**Our Case Number:** ABP-316178-23

**Re:** Proposed development of Oweninny Windfarm Phase 3 consisting of 18 no. wind turbines.  
Within the townlands of Laghtanvack, Croaghaun (also known as Croaghaun West), Moneynieran, Corvoderry, Shanvolahan, Dooleg More, Shranakilly, Bellacorrick and Shanvodinnaun, Co. Mayo.

Please be advised that the Board, in accordance with section 37(F)(1) of the Planning and Development Act 2000, as amended, hereby requires you to furnish the following further information in relation to the effects on the environment of the proposed development: .

Overview Sheet

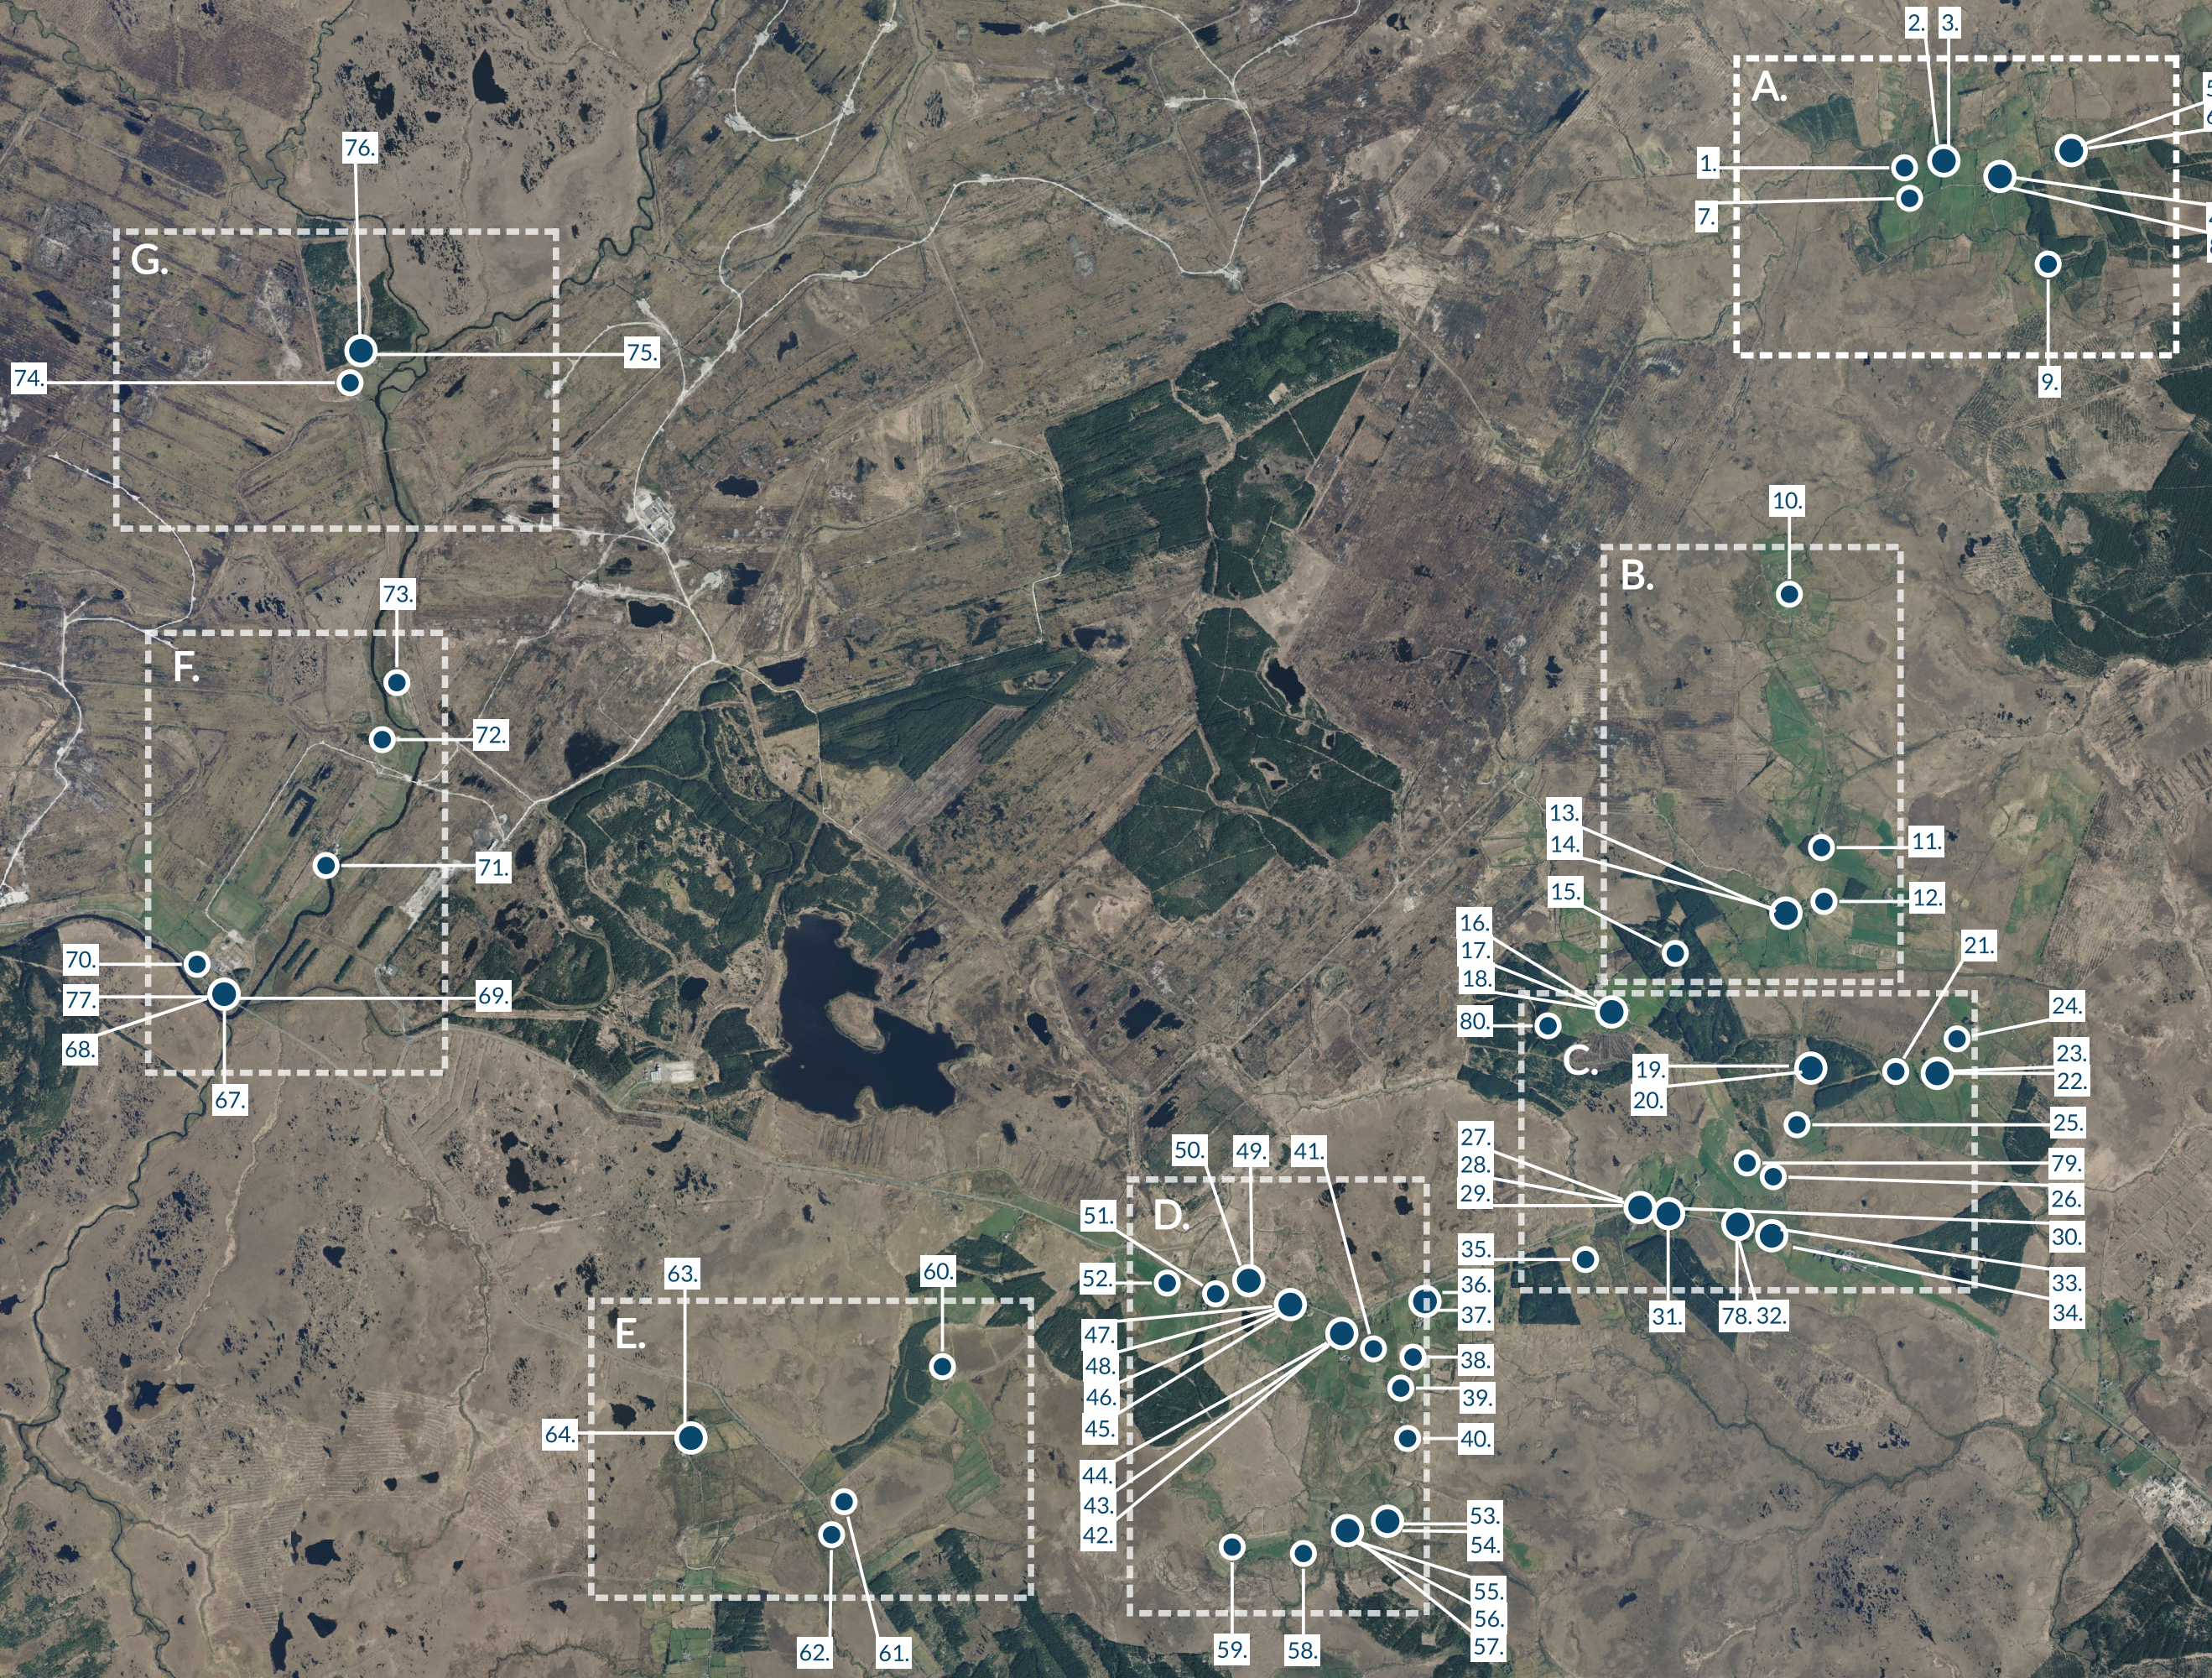
**1. Site Layout Plan:**

Submit a site layout plan which indicates the location of existing structures and development on site, including turbines and access roads. The site layout plan shall also indicate the turbines and access roads of adjoining windfarm developments such as Phase 1 and Phase 2 Oweninny windfarm. Annotate and label the turbines (both on and off site). Indicate the extent of existing access track to be retained as part of the proposed development.
